Address: 12 Park Close Huddersfield HD8 8JF

Application number: 2023/91316	
What is the application for?:	Demolition of existing garage and erection of single storey side and rear extens
Address of the site or building:	10, Park Close, Shelley, Huddersfield, HD8 8JF
Postcode:	HD8 8JF

Client	Mr & Mrs Dolley	Issued From	
Project	2375 : 10 Park Close : Domestic Extension	Date	March 2023
Title	Existing and Proposed Site Plans	Scale	1:100 @ A1
Drawn	BH	Auth	BH

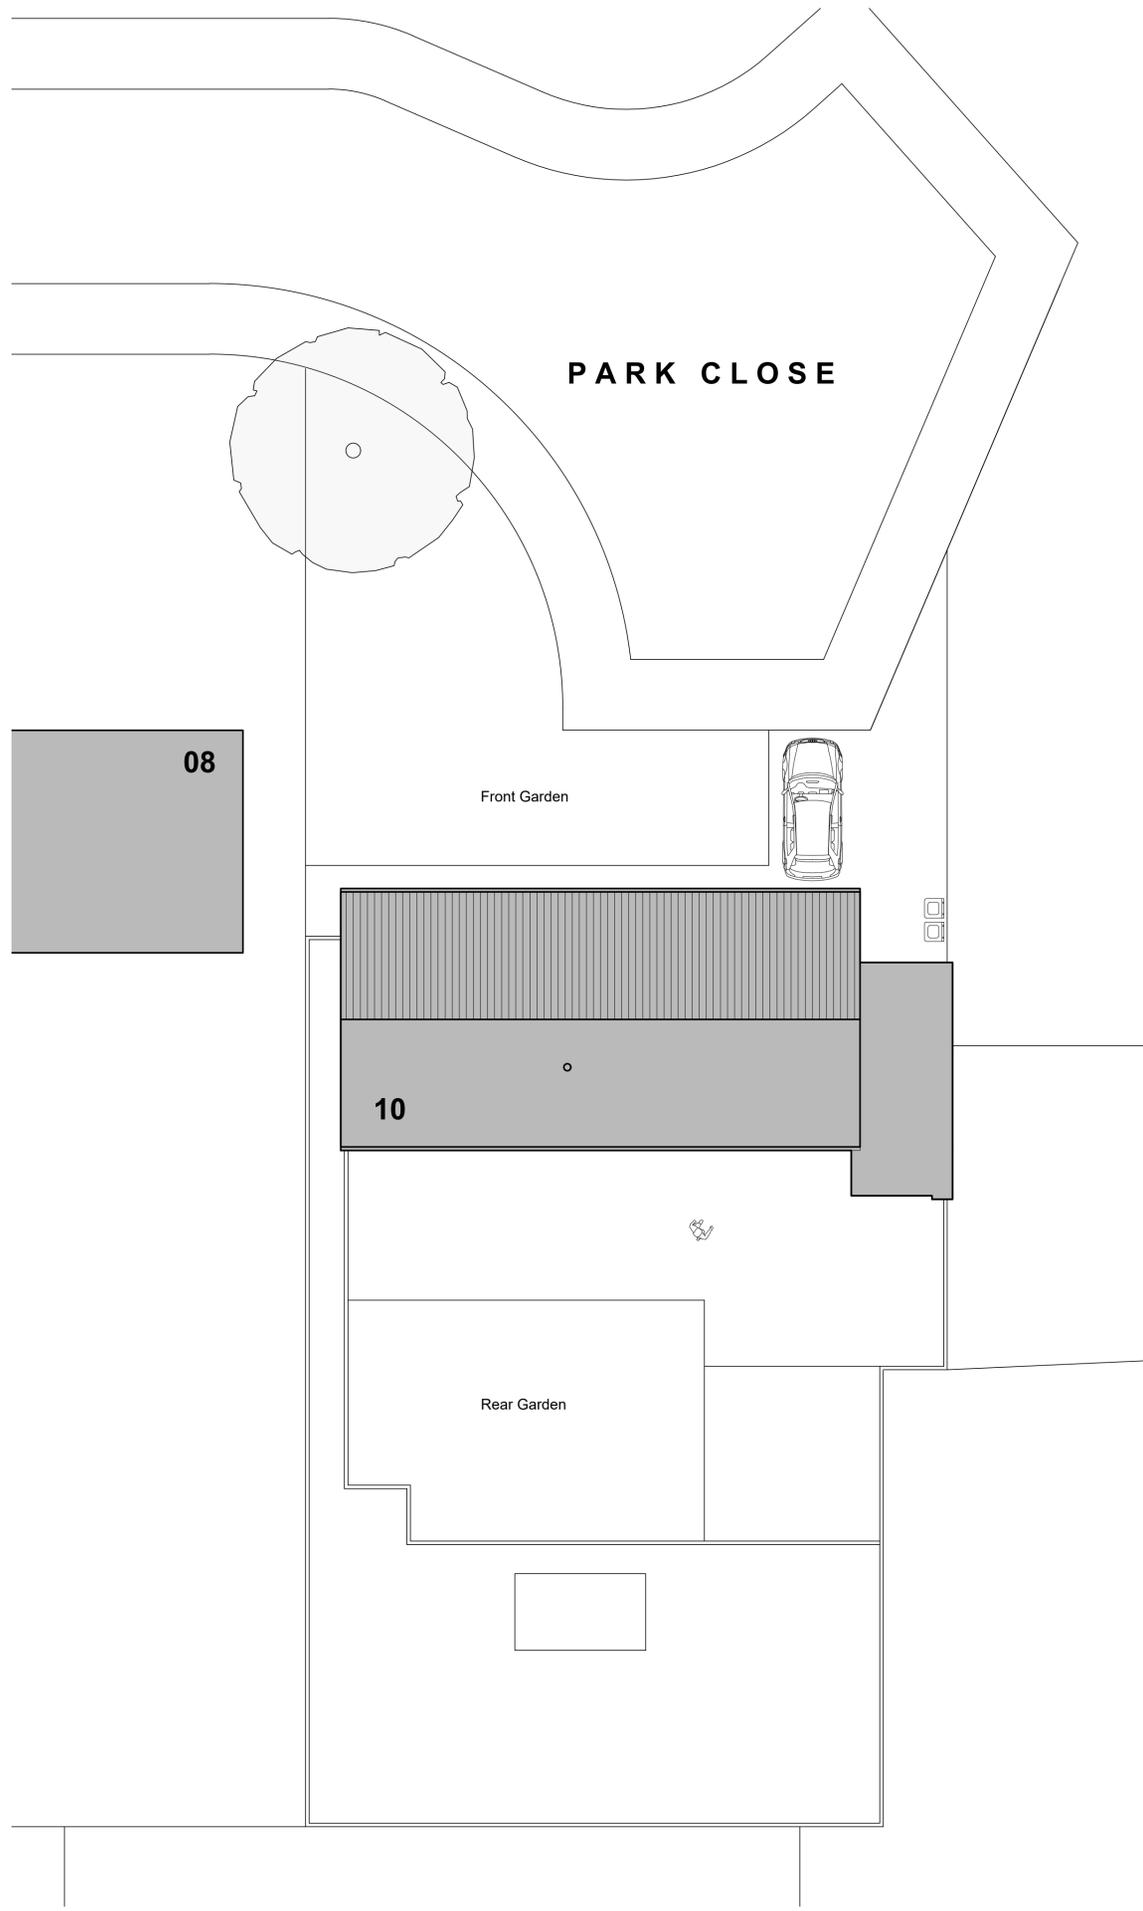
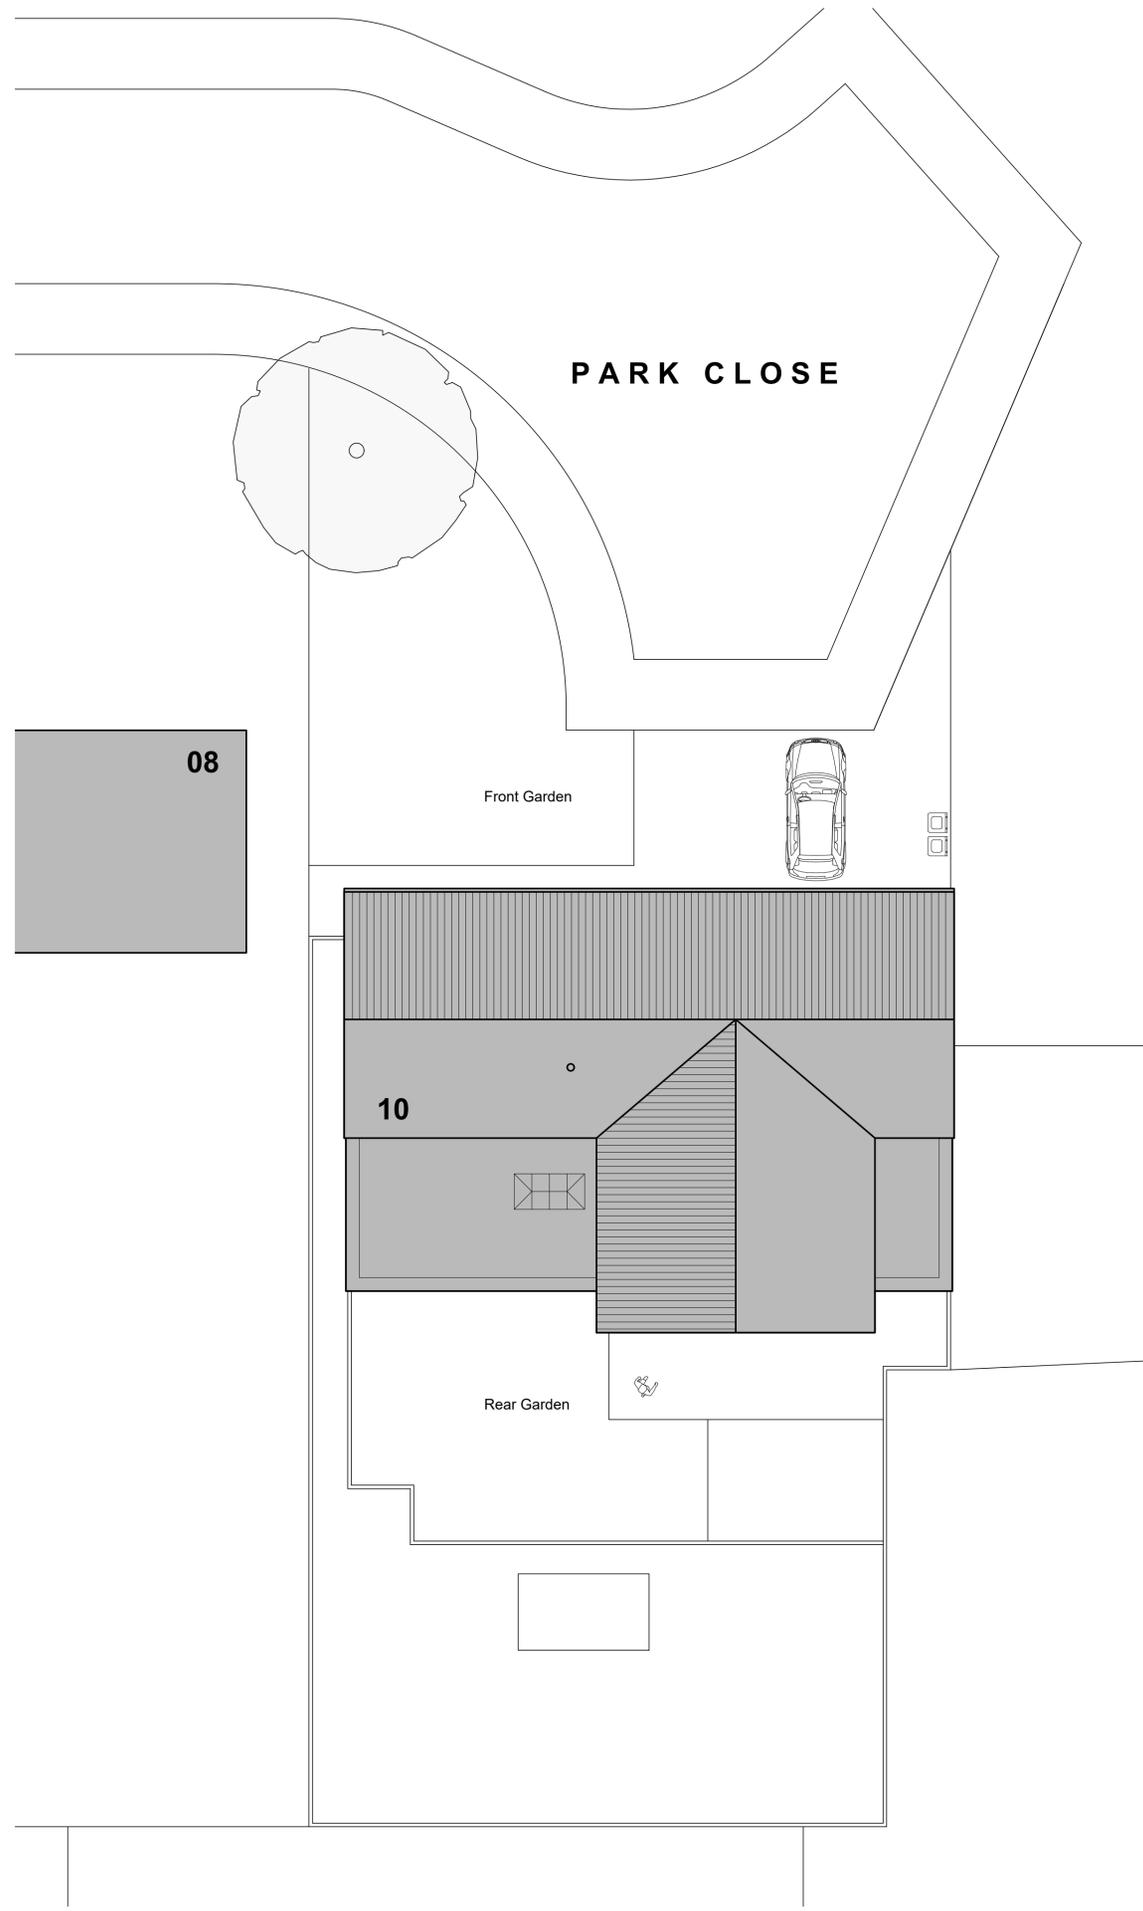
Type of comment: A general comment	
Do you wish your comments to be published on the website anonymously?	No
The boundary shown on the plan between no 12 and no 10 is incorrect and not as registered with the land registry. It would appear that the line marked as the boundary is in fact the line of my hedge the actual boundary being a little further towards no 10 and being marked by a low stone wall alongside the drive of no 10, terminating at the pavement edge at the top of the drive. The plan shows it continuing along the front of no 12.
